**WELWYN HATFIELD BOROUGH COUNCIL
EXECUTIVE DIRECTOR - PLANNING, PUBLIC PROTECTION AND GOVERNANCE**

DELEGATED APPLICATION

Application No: 6/2020/2817/LAWP
Location: 99 The Ridgeway Cuffley Potters Bar EN6 4BG
Proposal: Lawful development certificate for the demolition of existing car port, attached outbuildings and sun room to facilitate erection of a single storey side and two storey rear extension, to include rear facing Juliette balcony and 2 dormers to both sides of existing roof.
Officer: Ms Lois-May Chapman

Recommendation: Granted

ROOF PLAN

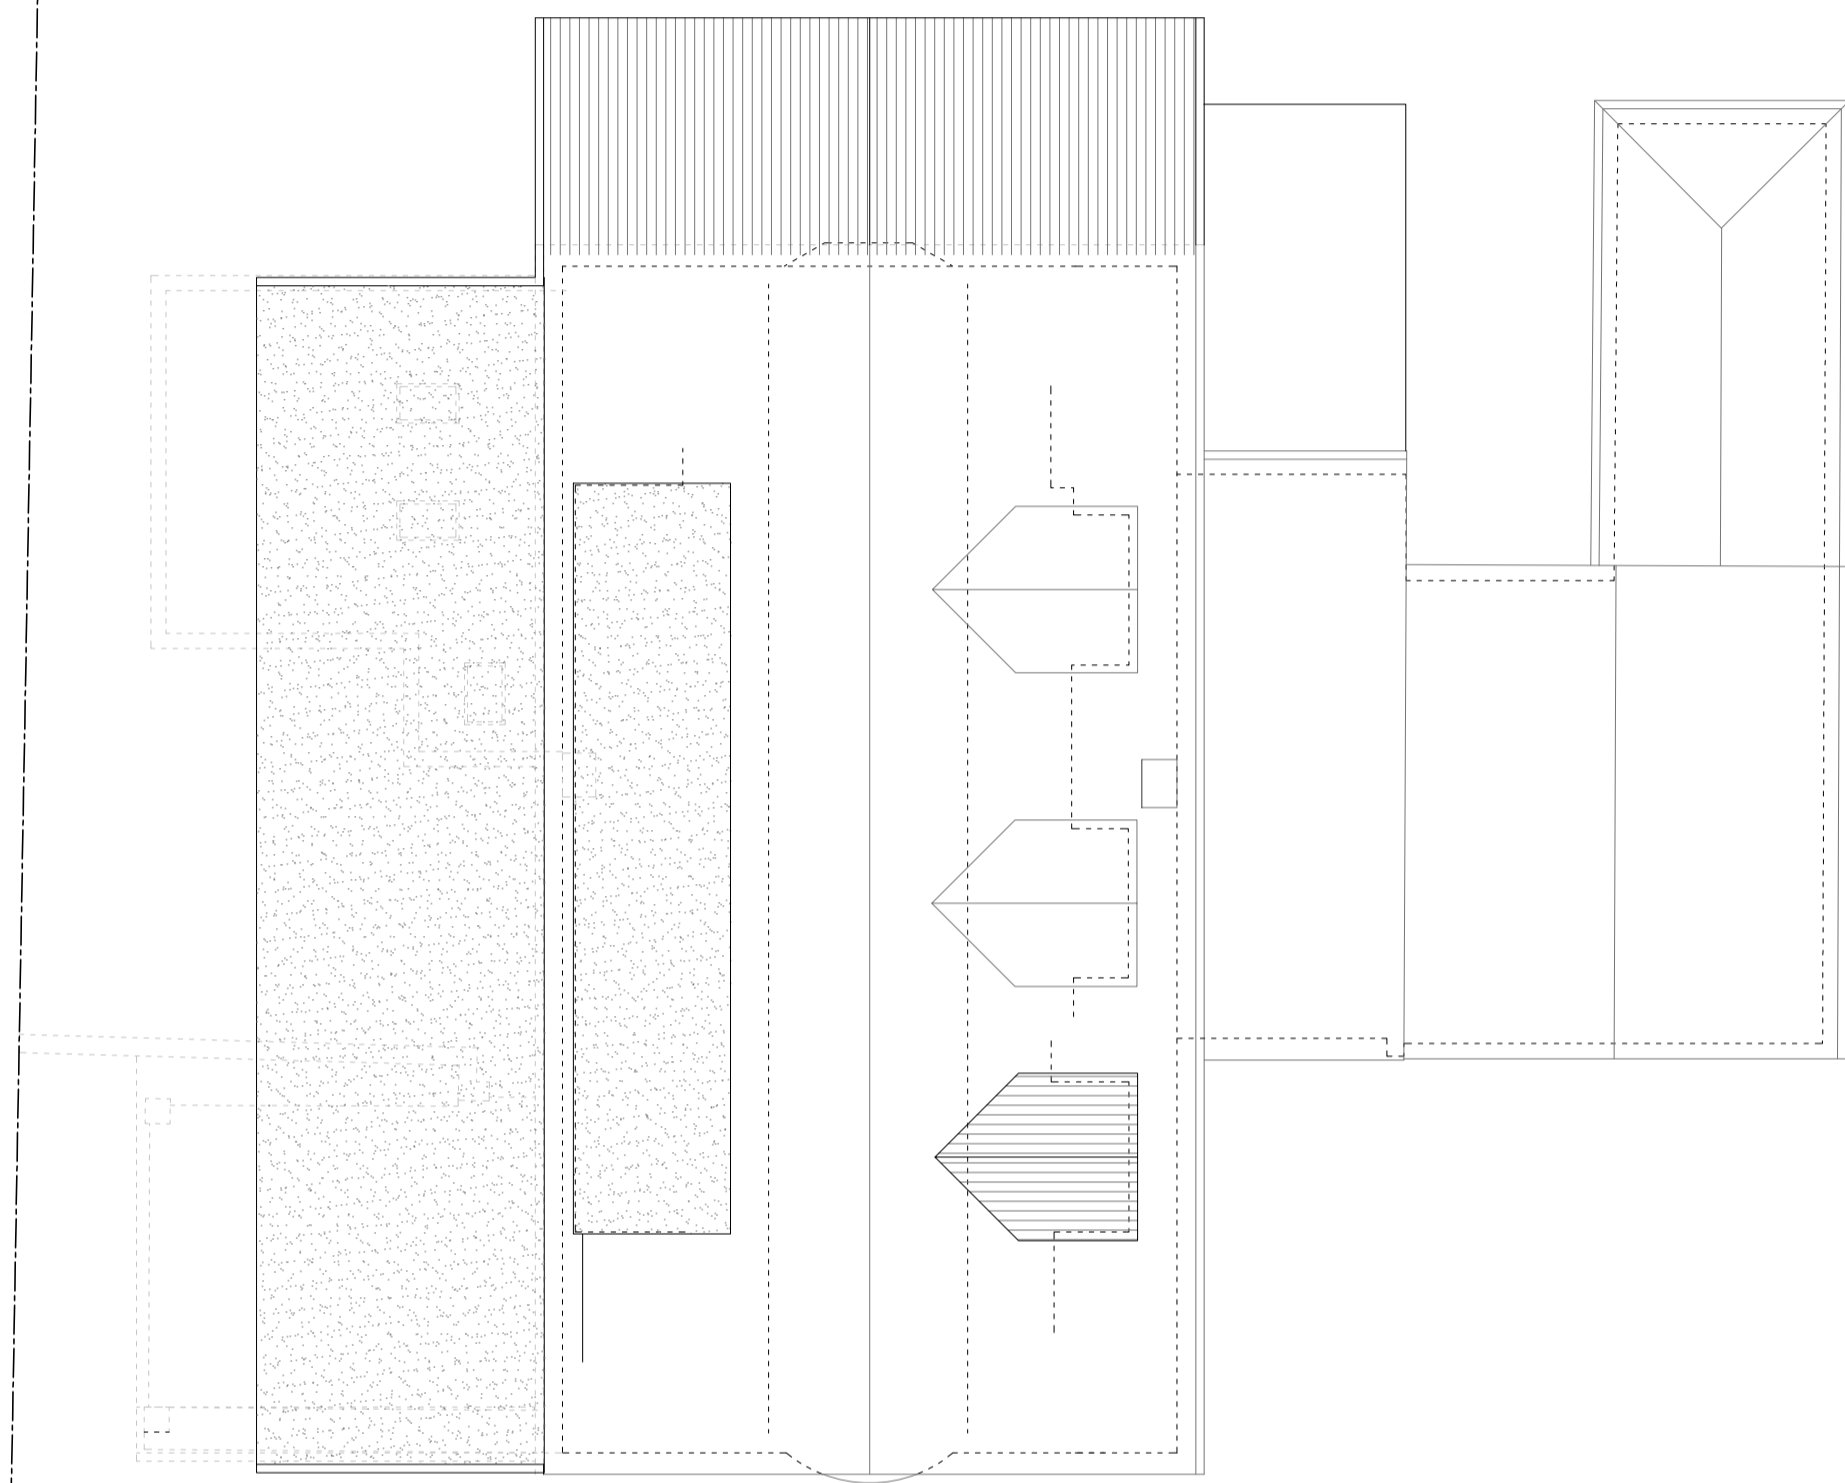
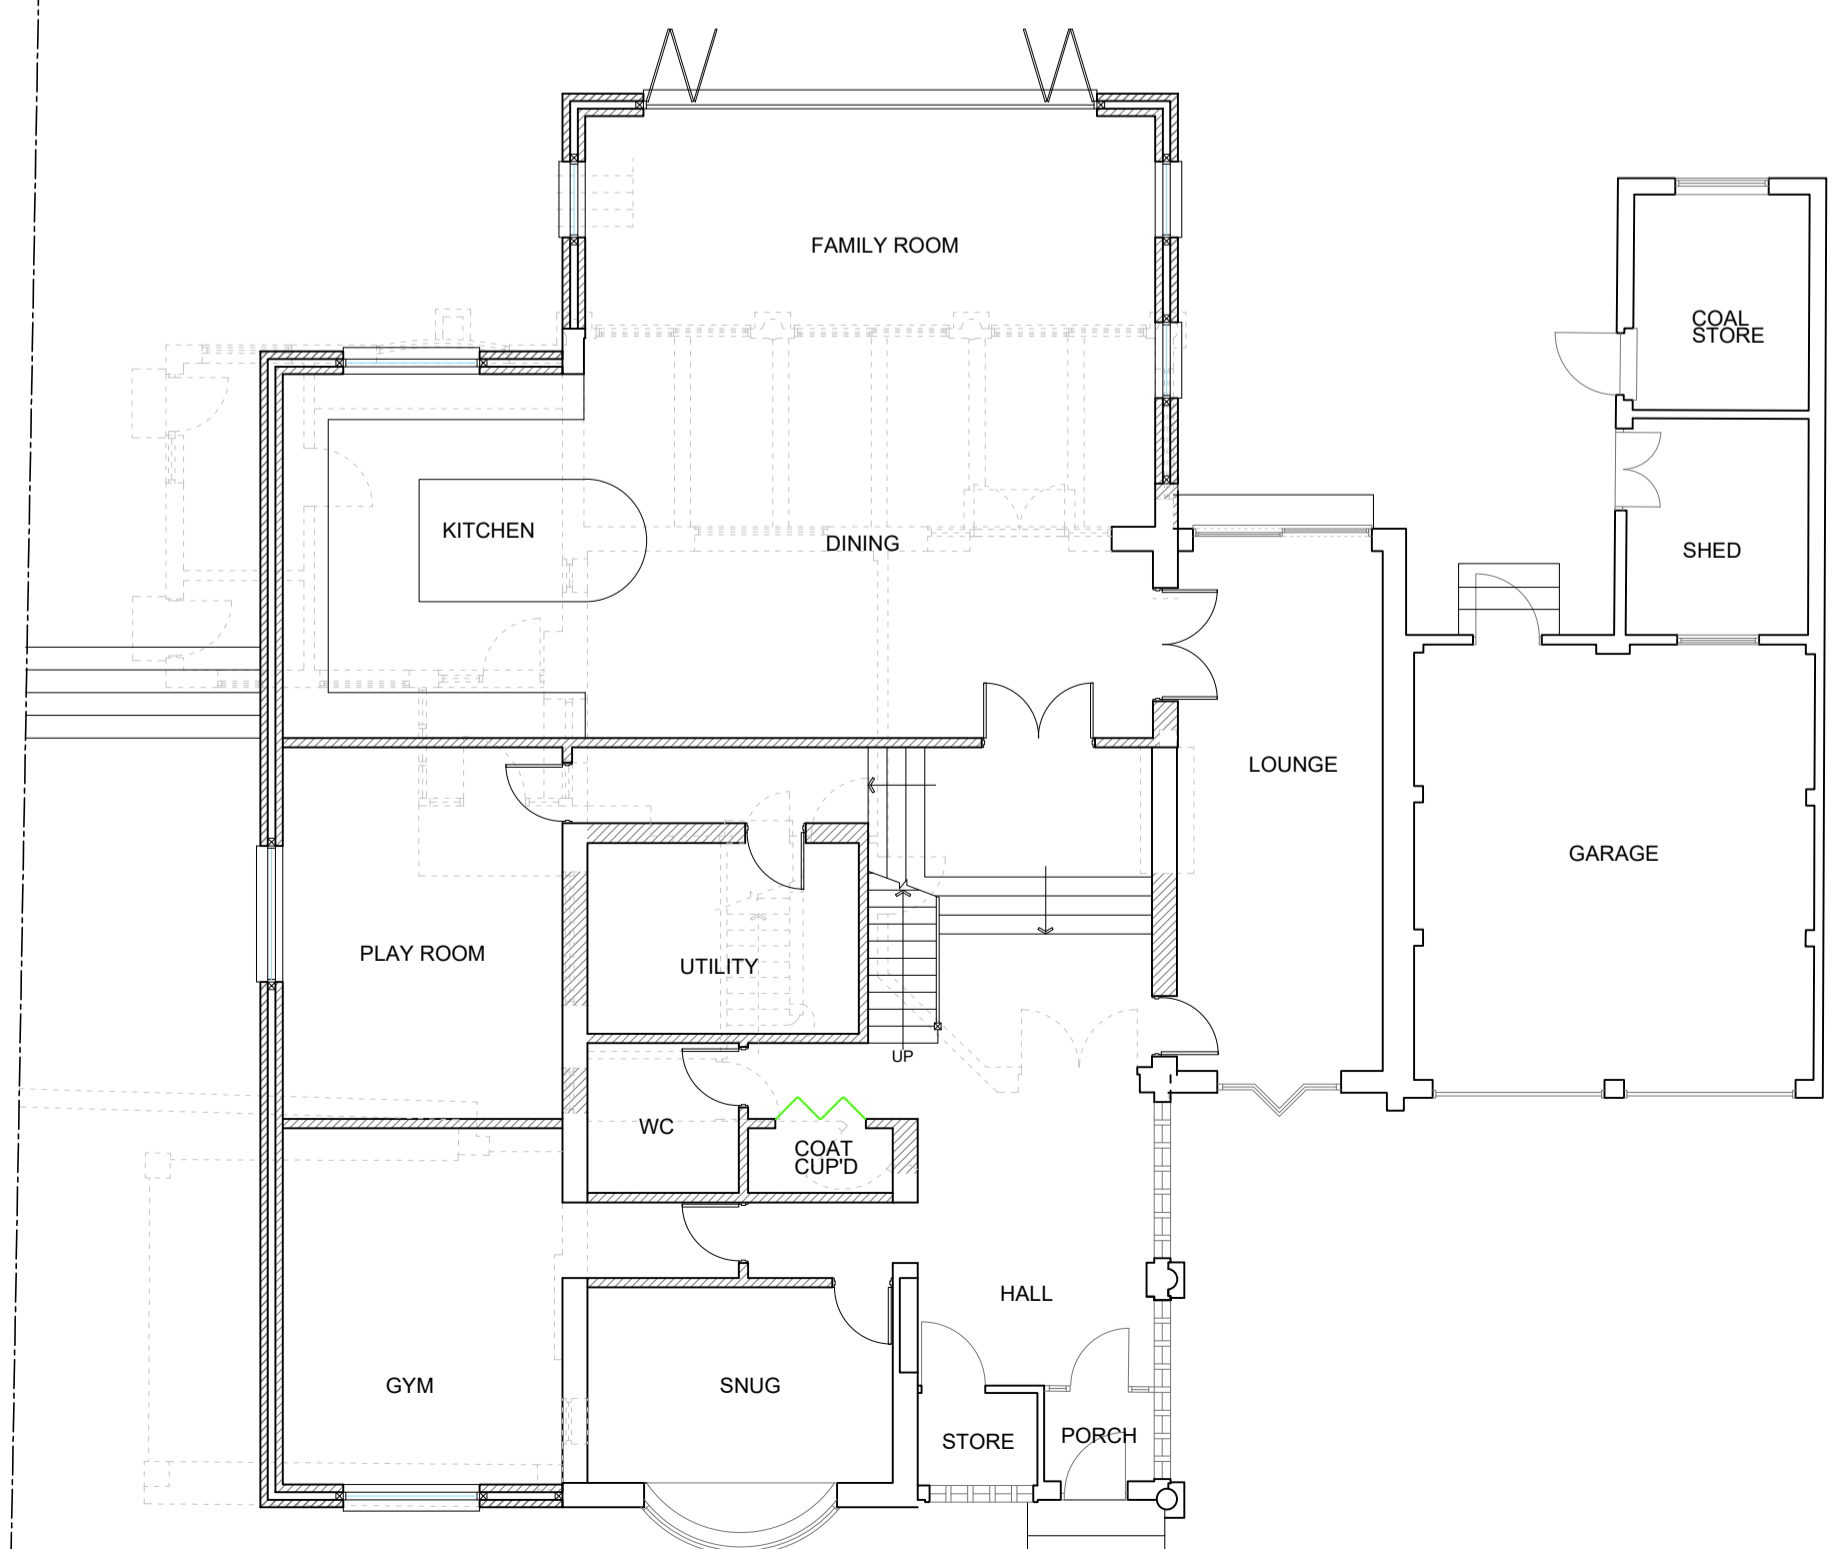
(d) would the cubic content of the resulting roof space exceed the cubic content of the original roof space by more than:- (i) 40 cubic metres in the case of a terrace house, or (ii) 50 cubic metres in any other case		N
<p>Dormers: <i>Two of the small dormer windows on the inside roof slope were original, as were two smaller dormer windows on the outside roof slope</i></p> <p>Additional volume created by the large dormer to the outside roof slope:</p> <p>Proposed dormer (1/2 x (9.8 (w) x 2.0 (h) x 2.1 (d)) = 20.58 m³</p> <p>Original dormers ((1/2 x (3 (w) x 1.2 (h) x 1.2 (d)) + (1/6 x (3.2 (w) x 1.8 (h) x 2.9 (d))) + ((1/2 x (2 (w) x 1.2 (h) x (1.2 (d)) + (1/6 x 2.2 (w) x 1.5 (h) x 2.7 (d))) = 11.47 m³</p> <p>Proposed – original: 20.58m³ – 11.47m³ = 9.11m³</p> <p>Small dormer to the inside roof slope: Main body of the dormer: (1/2 x (2 (w) x 1.5 (h) x 1.5 (d)) = 2.25 m³ Roof of the dormer: (1/6 x (2 (w) x 1.2 (h) x 2.6 (d)) = 1.04 m³</p> <p>2.25m³ + 1.04m³ = 3.29m³</p> <p>Additional Roof Volume :</p> <p>½ x 6.5 (w) x 3.0 (d) x 3.2 (h) = 31.2m³</p> <p>9.11 + 3.29 + 31.2 = 43.6</p>
